| Application number: 2022/92799   |  |
| What is the application for?:    | Erection of extensions, conversion of existing attached barn to living accommoda |
| Address of the site or building: | 17, Town Gate, Upperthong, Holmfirth, HD9 3UX                                    |

Number
4416-05-06c
Date
06/2022
Scale @ A1
As Marked

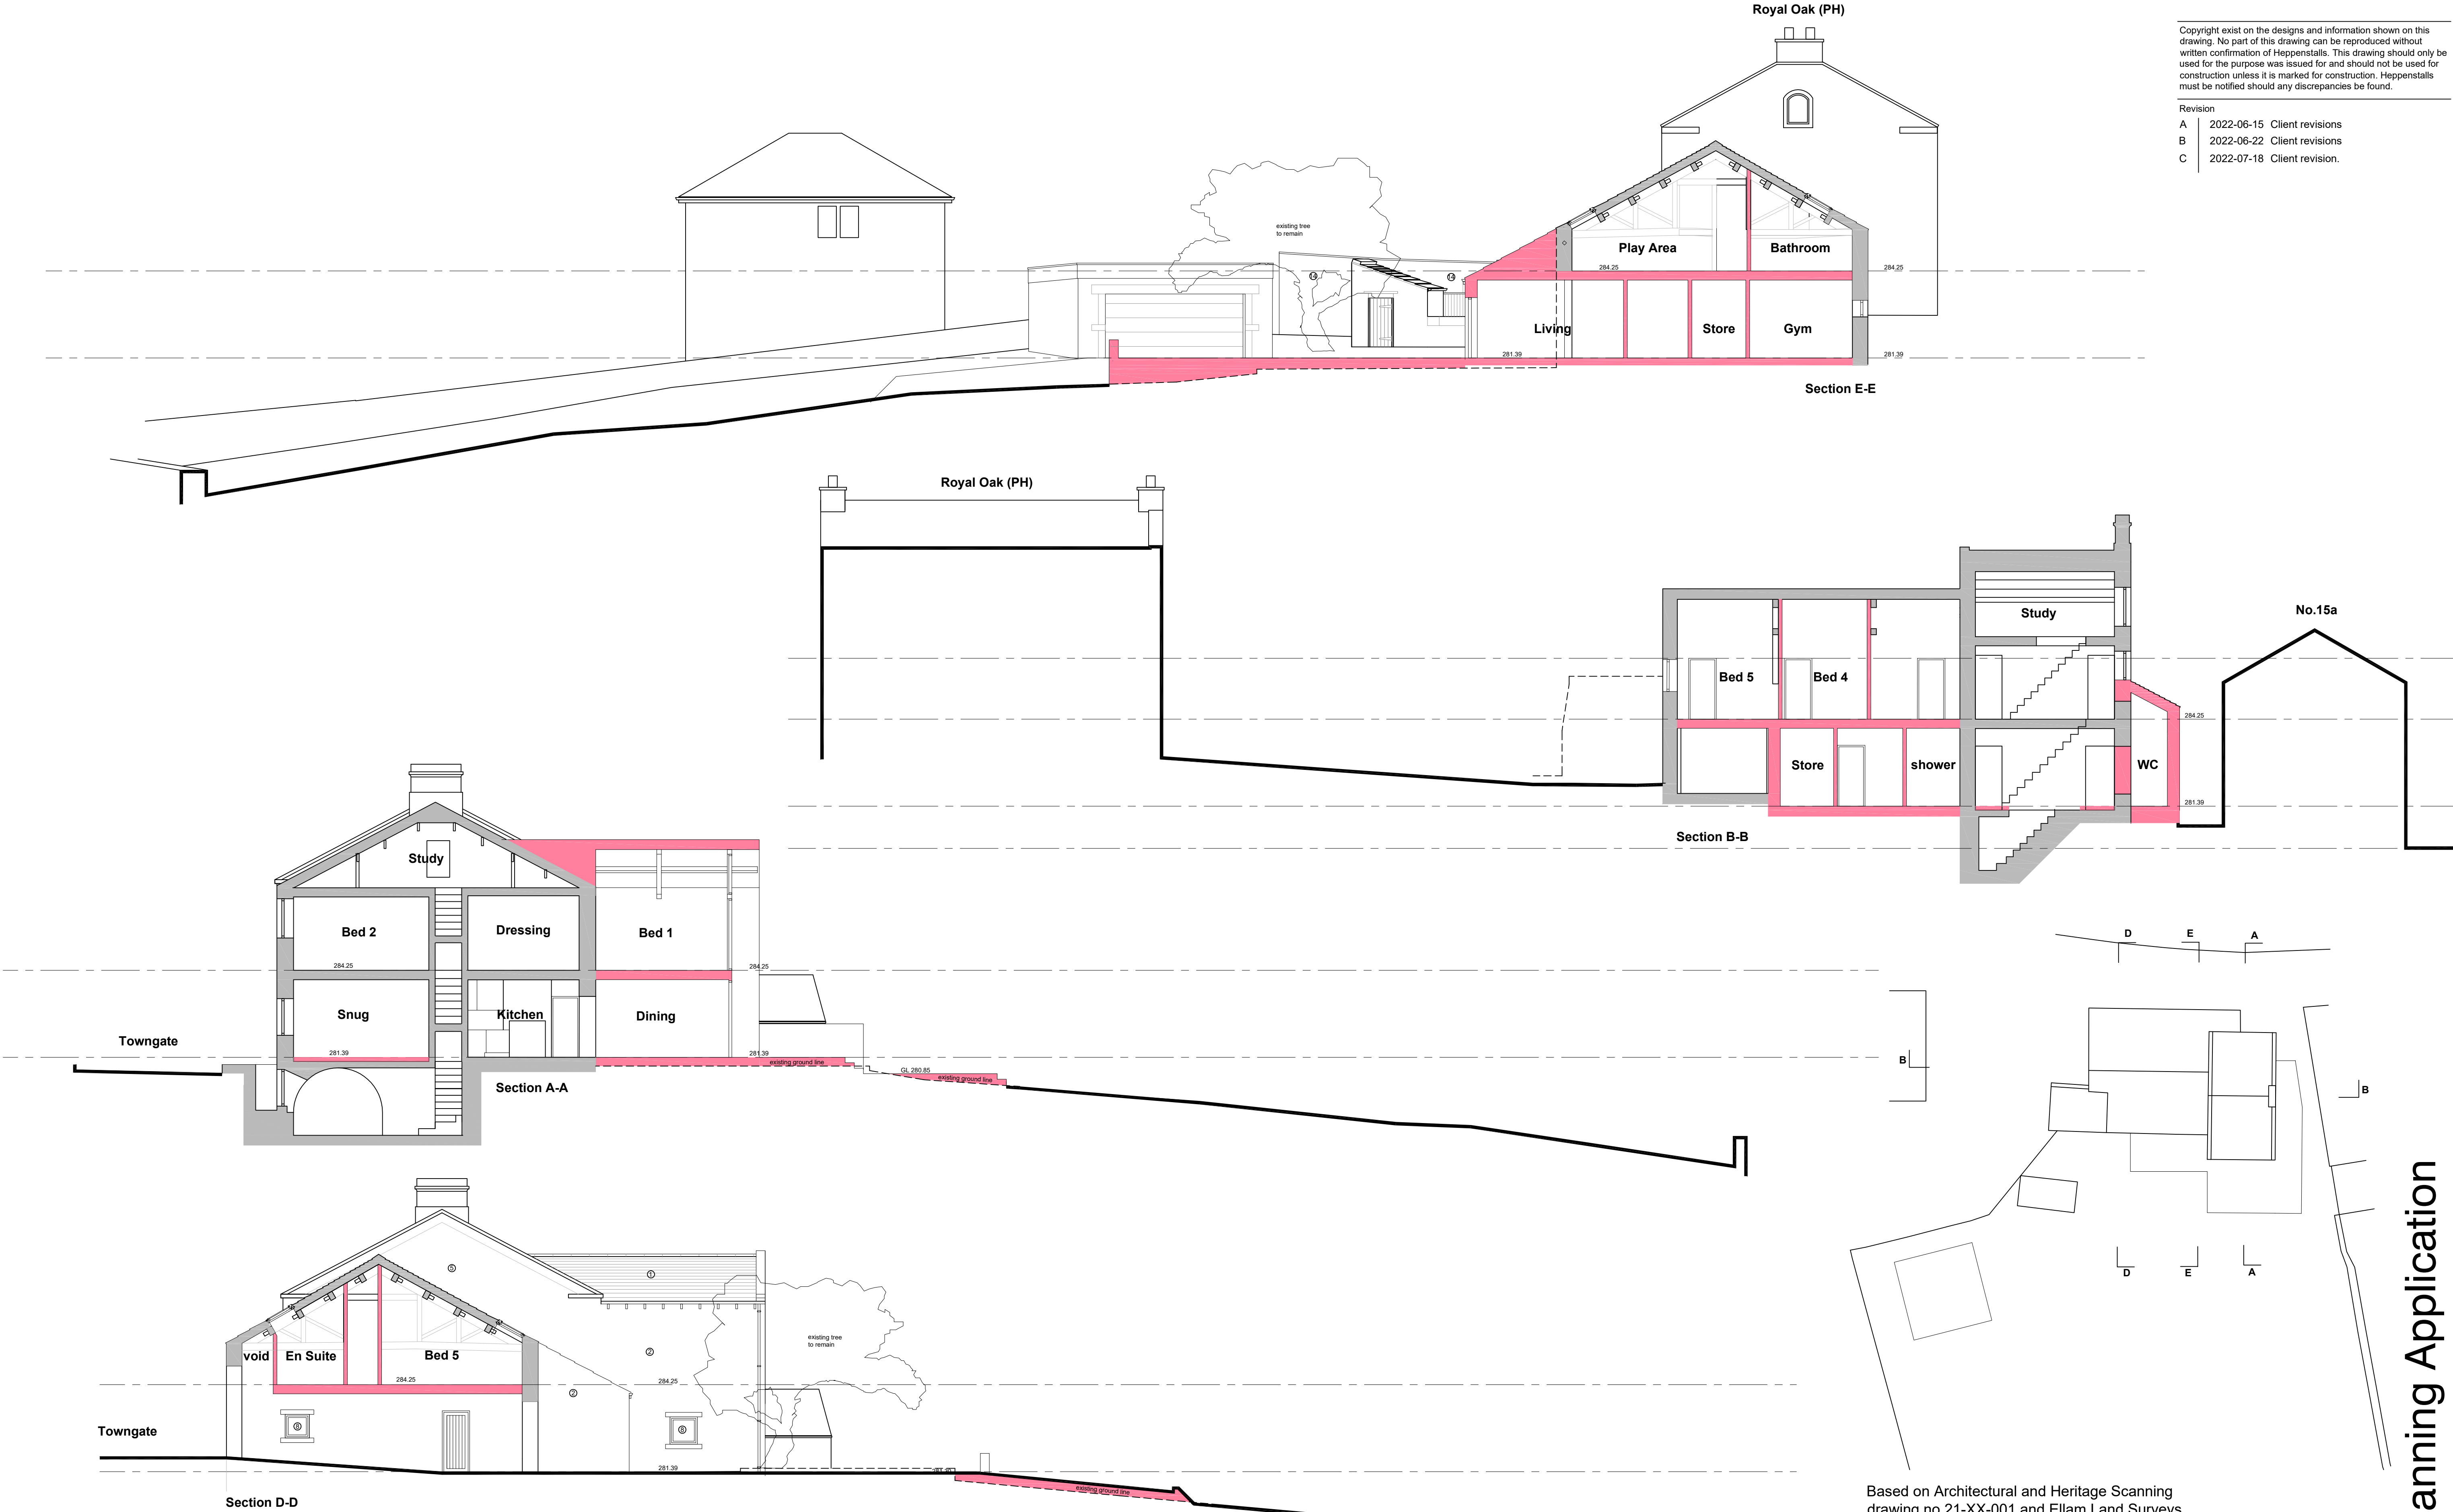
| <p>The application proposes the height of the existing retaining wall of the Royal Oak car park to be raised to 1.8m. This wall would obscure the view due south from the road (Town Gate) and have a dramatic negative effect on the character of the area. Currently the view south from the road and The Royal Oak car park over the Holme valley and up towards Holme Moss is one of natural beauty that is available to all members of public who pass by. As a result this proposed wall would ruin the natural landscape of the area to one which would be enclosed, ruining a view that has always been adored and cherished.</p> |                              |
